Online Comment

Application H11-0699-22
Location Land Adj. 6 St James Road Long Sutton Spalding PE12 9AU
Proposal Residential Development - 6 Affordable Housing Units - outline approval H11-0936-18

Name Elaine Ferguson
Address Housing Strategy

Plots 1 - 6 3 bed semi detached houses 97m2 (1044sqft) GIFA

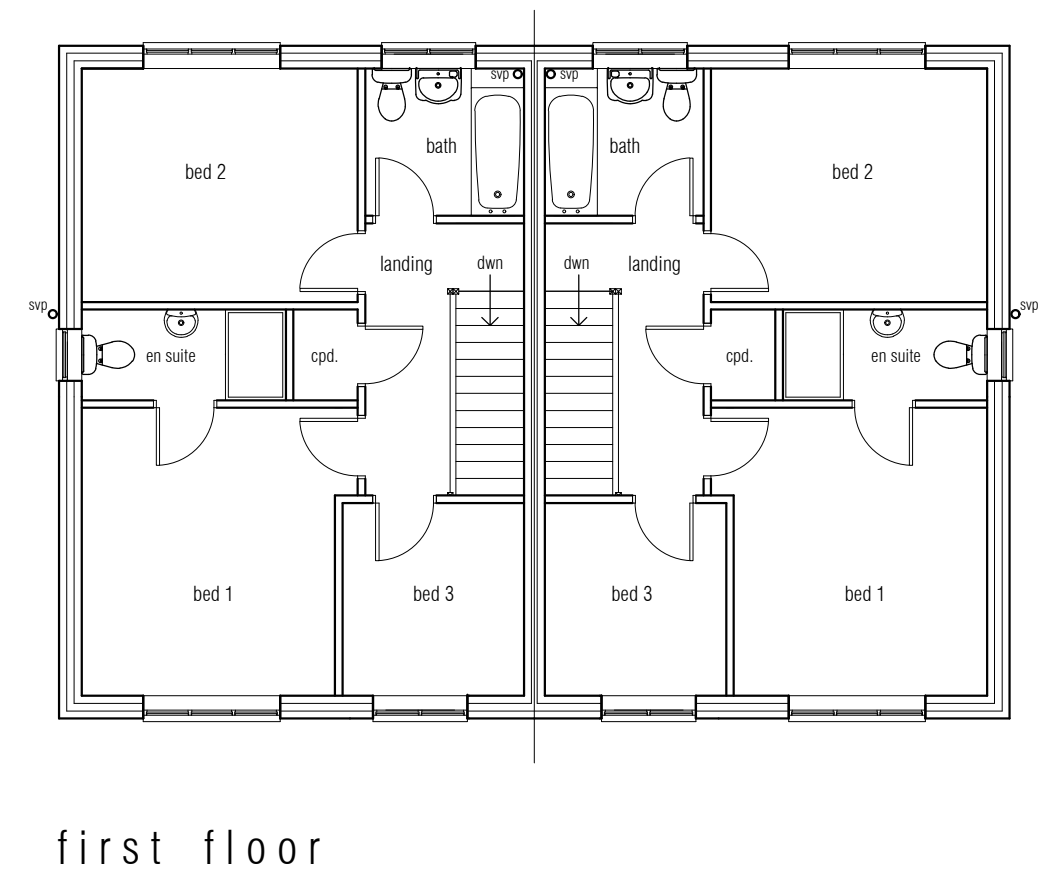
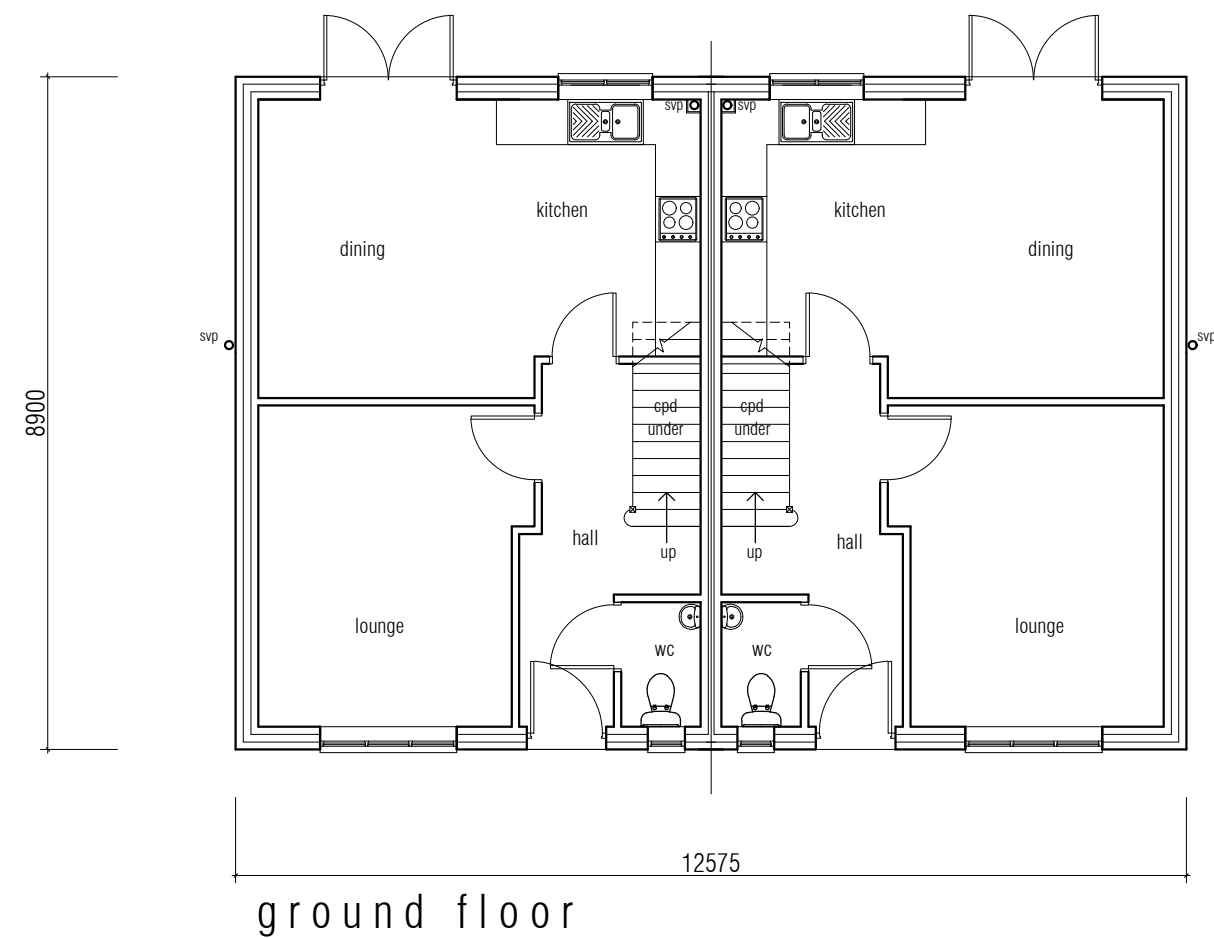
The site is in a rural location over the main A17 from the market town of Long Sutton. The site is outside the Long Sutton settlement limit. Although located in a rural area the site does not meet the criteria to be considered a Rural Exception Site. The site has received outline planning approval and benefits from a S106 which provides for 6 affordable homes. The current application proposes 6 x 3 bed houses, as indicated in Floor Plans Drawing DCF/SCr/pl/002. The homes are Discount Market Sales homes.

It would be preferable for the homes to be built to the 'Nationally Described Space Standards' at 1 bed 2 person 2 storeys, 2 bed 4-person 2 storey and 3 bed 5 person 2 storeys, although this is encouraged but not a requirement of policy. I note from the sizes listed within the planning statement that none of the homes meet NDSS, but they do meet at least 85% of NDSS which is often a minimum requirement for Registered Providers (RPs). Local policy also encourages homes that are capable of adaptation over time so it would be useful to understand if any of the homes are proposed to meet either M42 or M43 standards. It would also be useful to understand if the homes are proposing any net zero carbon initiatives, again encouraged but not a policy requirement.

To conclude; the Discount Market Sales home is a type of intermediate affordable home product. There has been limited development of intermediate affordable Discount Market Sales homes across the district in the last 10 years in comparison with other intermediate types of affordable housing. Affordable intermediate rural homes in the main are shared ownership properties. For affordable home ownership a mix of 2 and 3 beds are mainly delivered and sought in the district, including 2 bed bungalows for shared ownership. Local housing need for the next 5 years for the Parish of Long Sutton for intermediate affordable housing indicates a housing mix, split of 18% 1 bed, 42% 2 bed house, 34% 3 bed and 7% 4 bed homes. Therefore, the preferred affordable housing mix is 4 x 2 bed houses and 2 x 3 bed houses.
